Our Reference: SYD12/00170/02
Your Reference: MP09_0146
Contact: Stella Qu
Telephone: 8849-2520

**SYDNEY
REGIONAL
DEVELOPMENT
ADVISORY
COMMITTEE**

**PROPOSED MIXED USE DEVELOPMENT
EASTLAKES SHOPPING CENTRE, EASTLAKES**

21 September 2012

PROJECT TITLE
EASTLAKES TOWN CENTRE
GARDENERS ROAD
EASTLAKES NSW 2018
DRAWING TITLE
DRAINAGE & ROAD MODIFICATION LAYOUT
SHEET 1

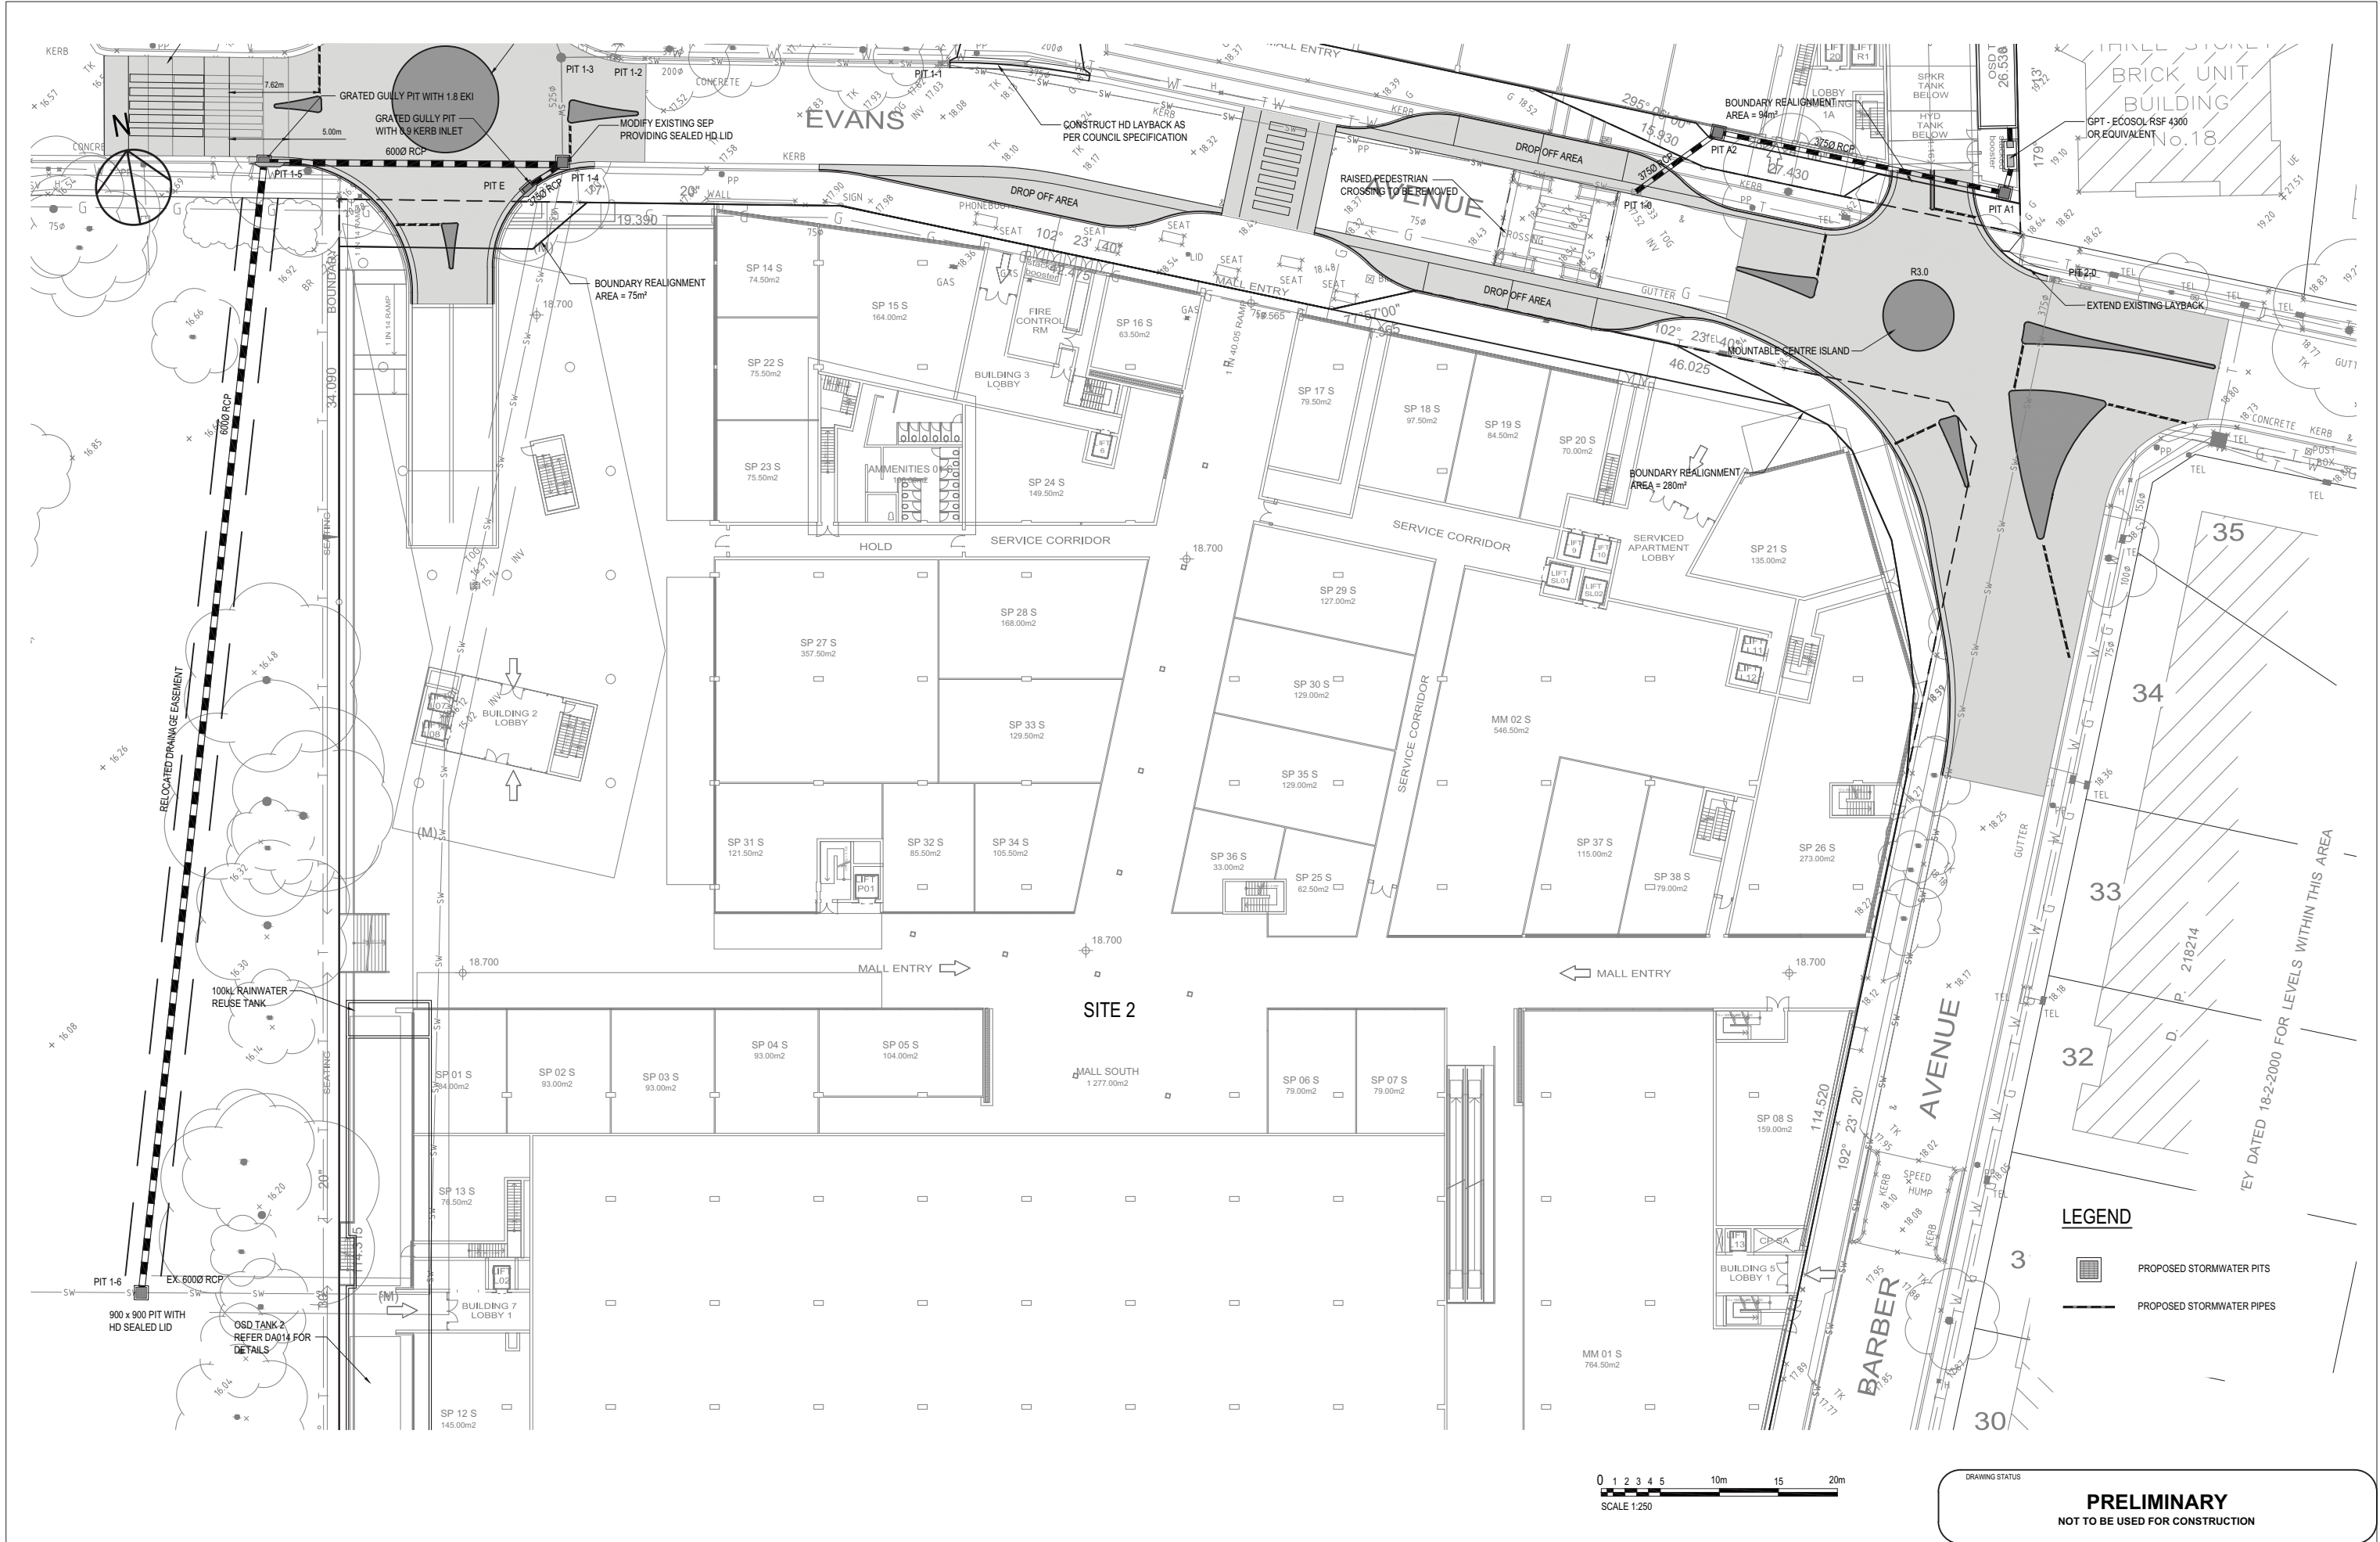
8. Detailed design plans and hydraulic calculations of any changes to the stormwater drainage system are to be submitted to RMS for approval, prior to the commencement of any works.
